MECKLENBURG COUNTY  
Park and Recreation Department

MEMORANDUM

**DATE:** March 27, 2024

**RE:** Rezoning Petition #2024-024  
PID#05142112

RZ-1.0

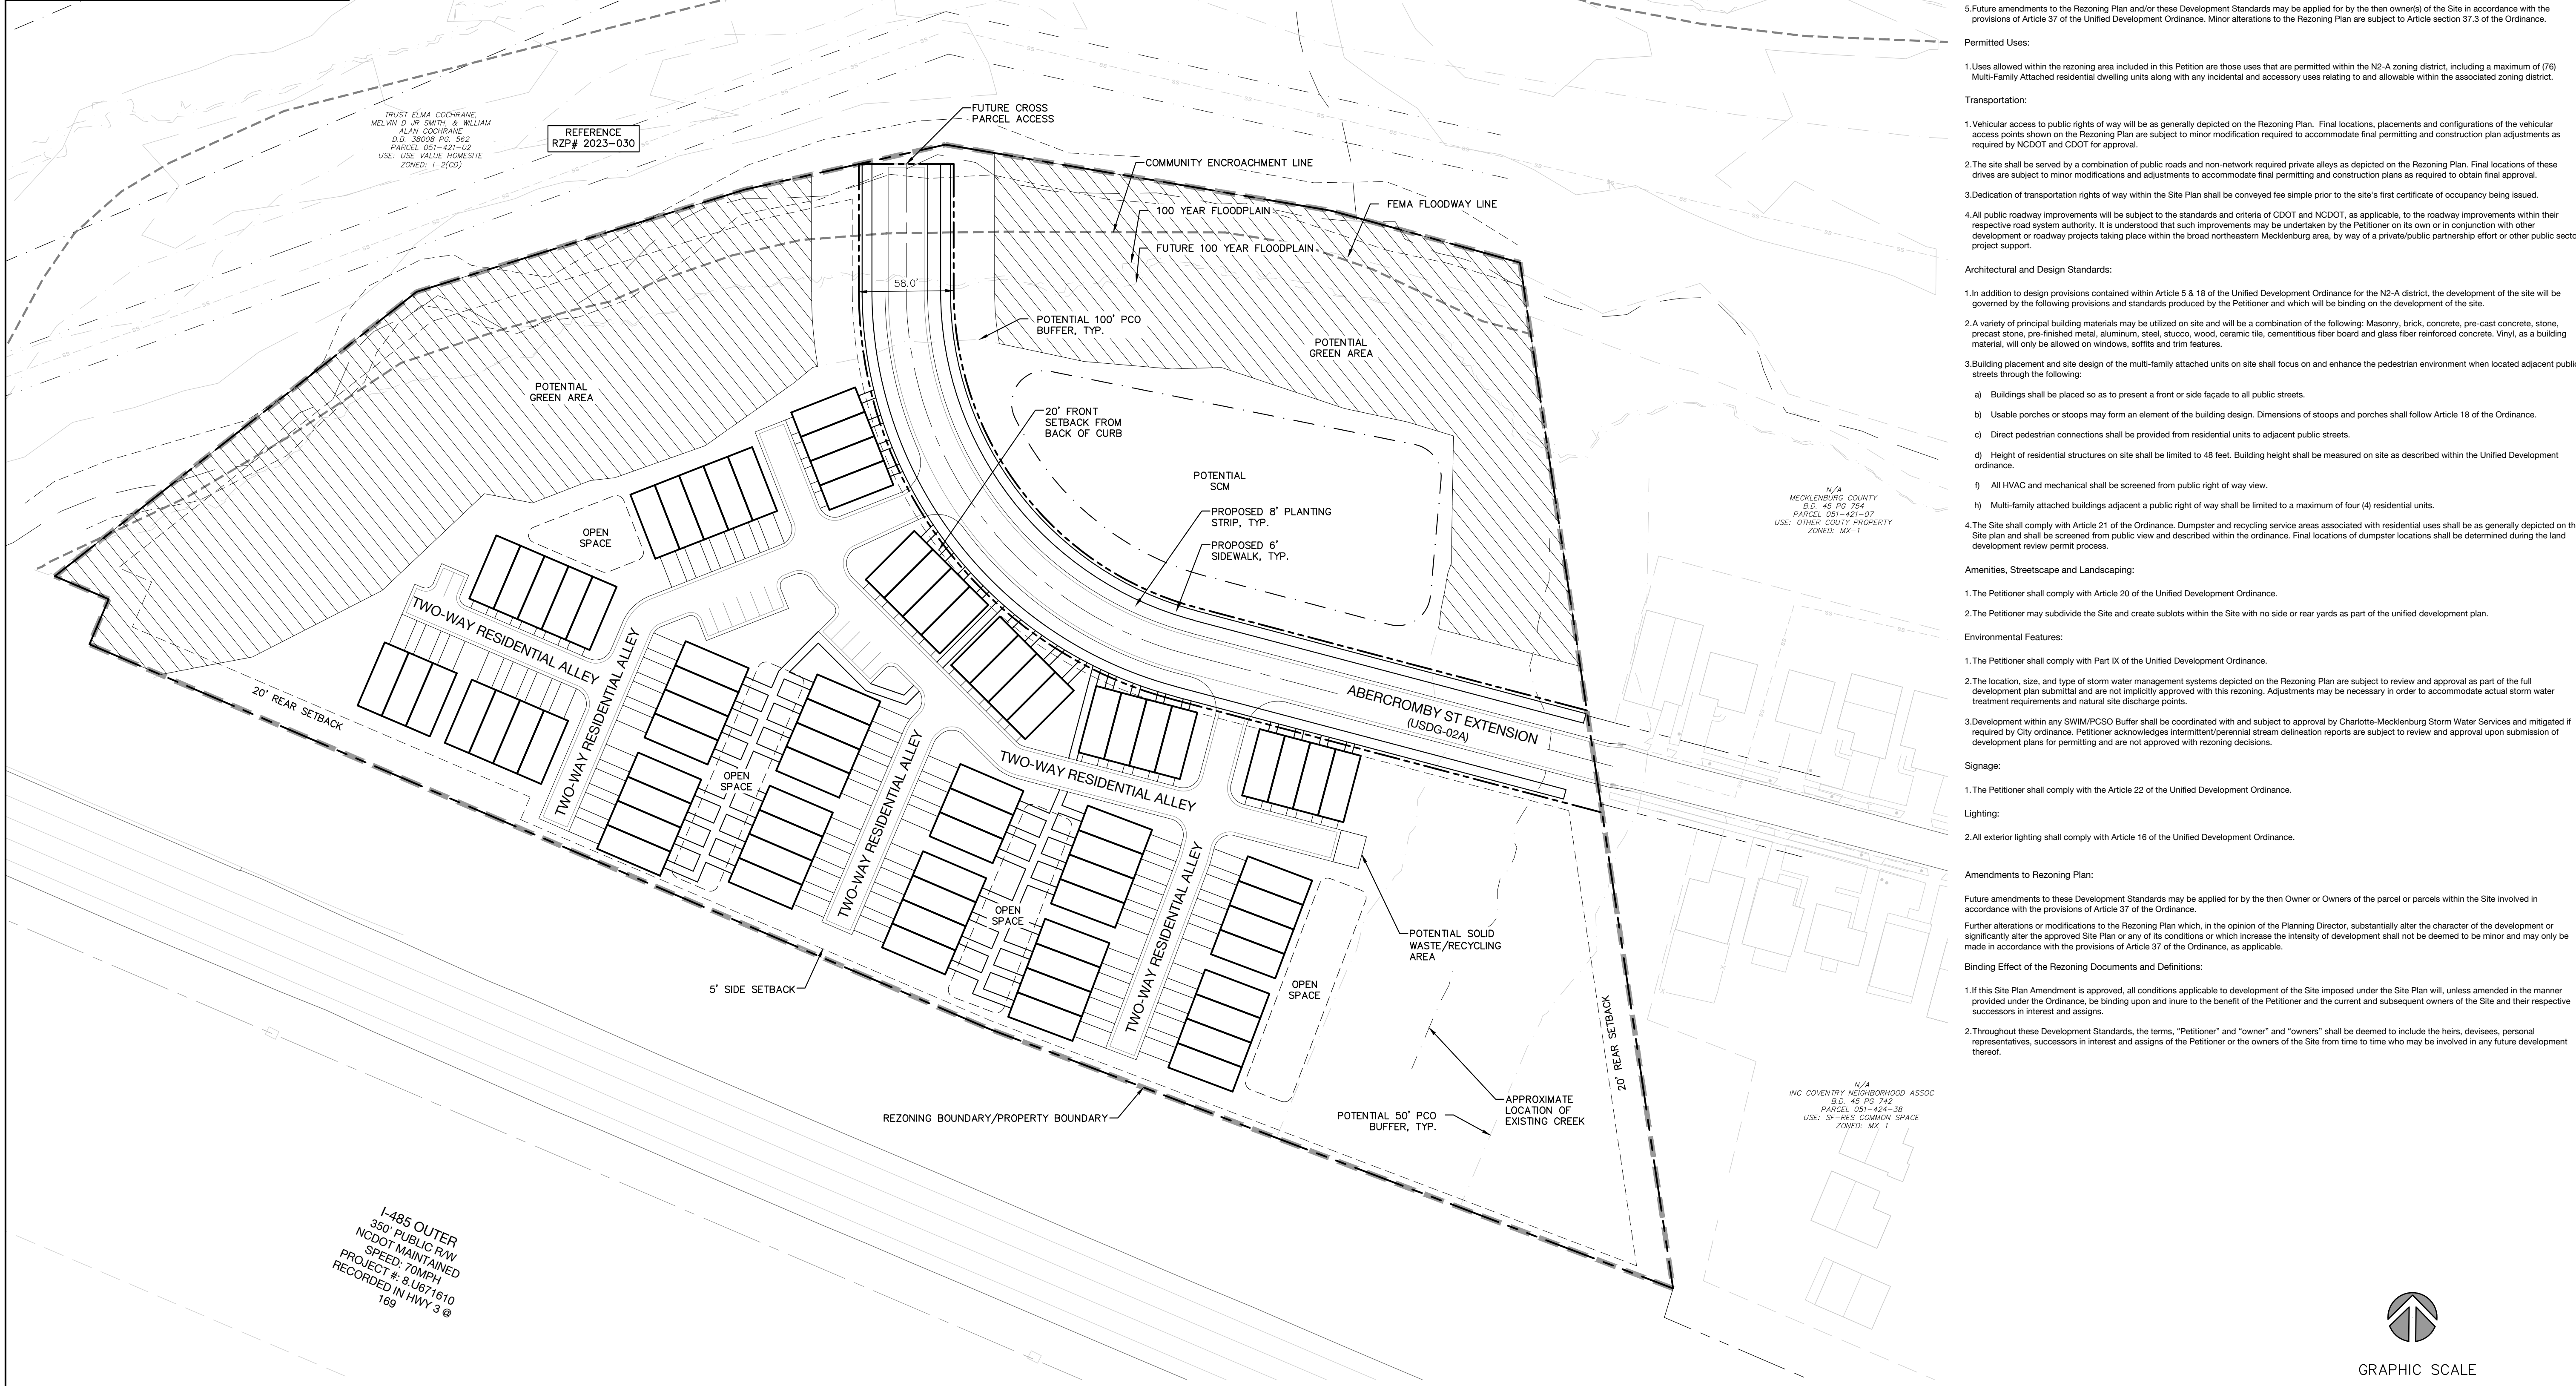
This parcel is on the Mecklenburg County Greenway Master Plan for Back Creek. We request the dedication and conveyance of the 100' SWIM Buffer of Back Creek to Mecklenburg County or a Greenway Easement of the same area. In addition, Mecklenburg County requests an access easement dedicated and conveyed to the new public right of way within the development. All greenway easements can be co-located within any required tree save.
